SCOPING OPINION:

Proposed Keadby 3 Low Carbon Gas Power Station Development

Case Reference: EN010114

June 2020

Figure 2B

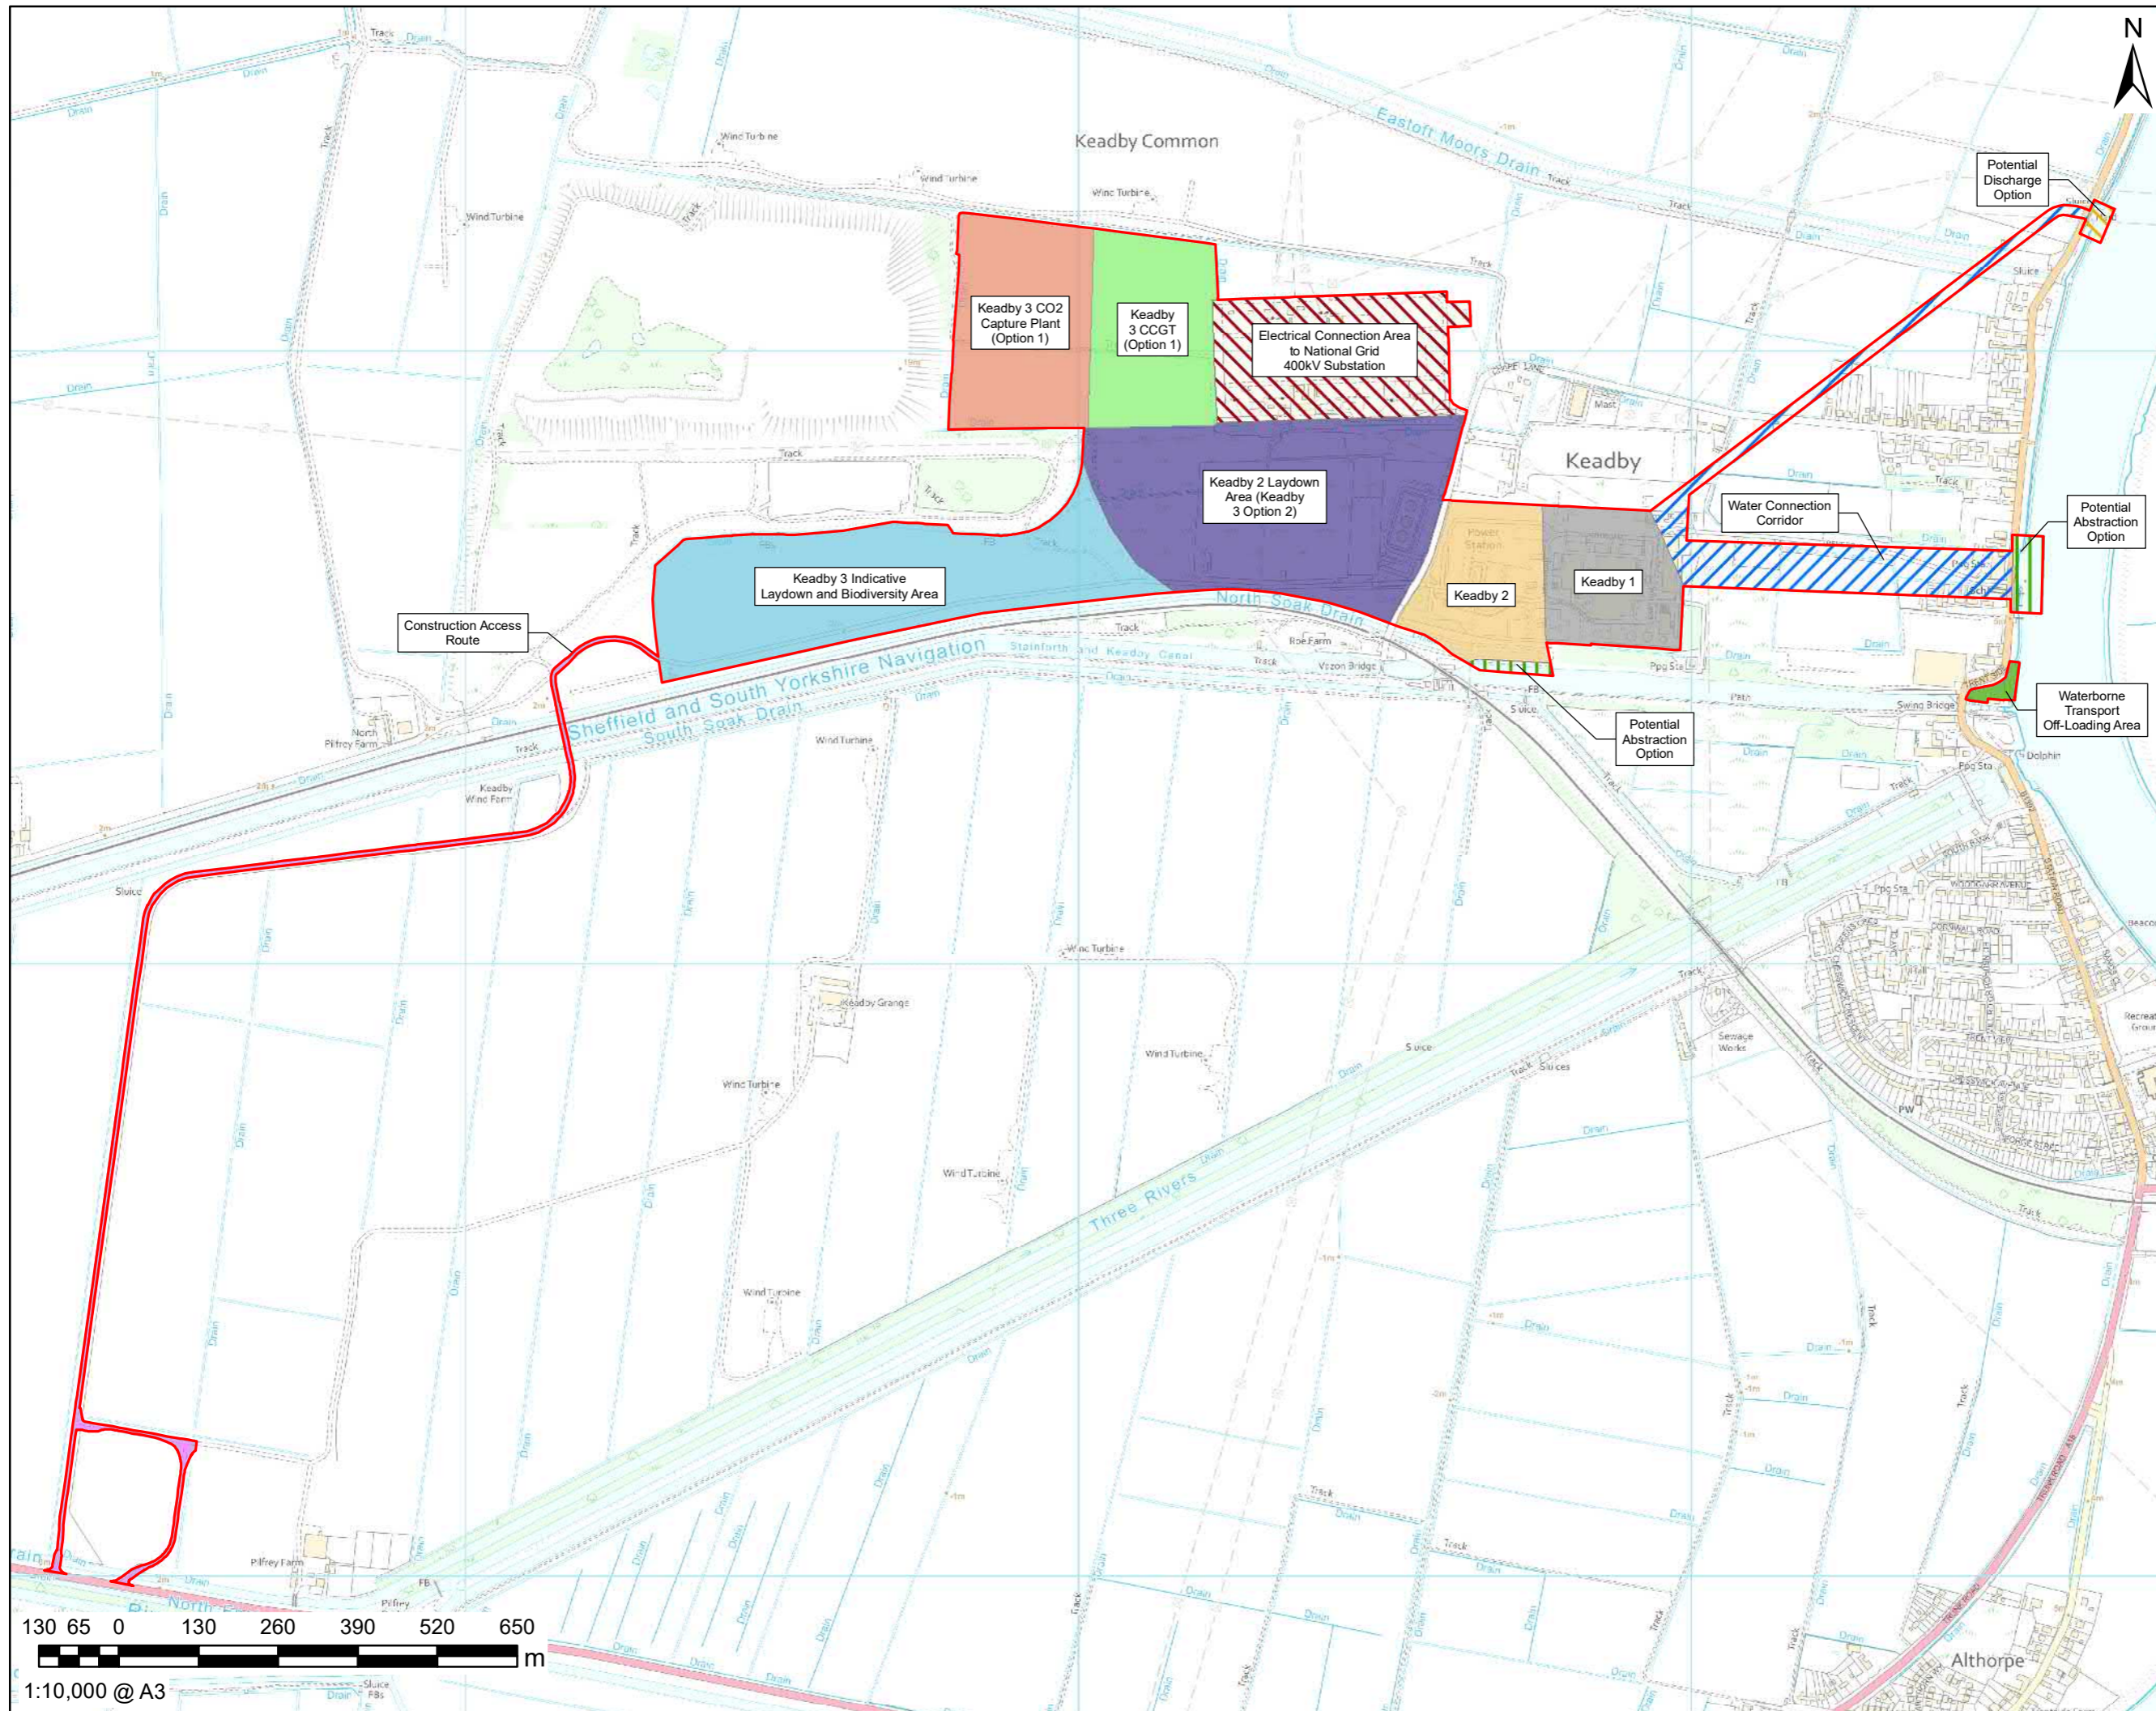
- 2.3.6 A large area is denoted on Figure 2B for the electrical connection to the existing substation. The figure does not denote where the gas connection options are. Paragraph 4.2 suggests that there are alternative options for both the gas and electricity network connections. The ES should provide greater clarity regarding the connections and effort should be made to refine the options and remove uncertainty. However, where uncertainty remains the assessment should be conducted in accordance with a worst-case scenario.
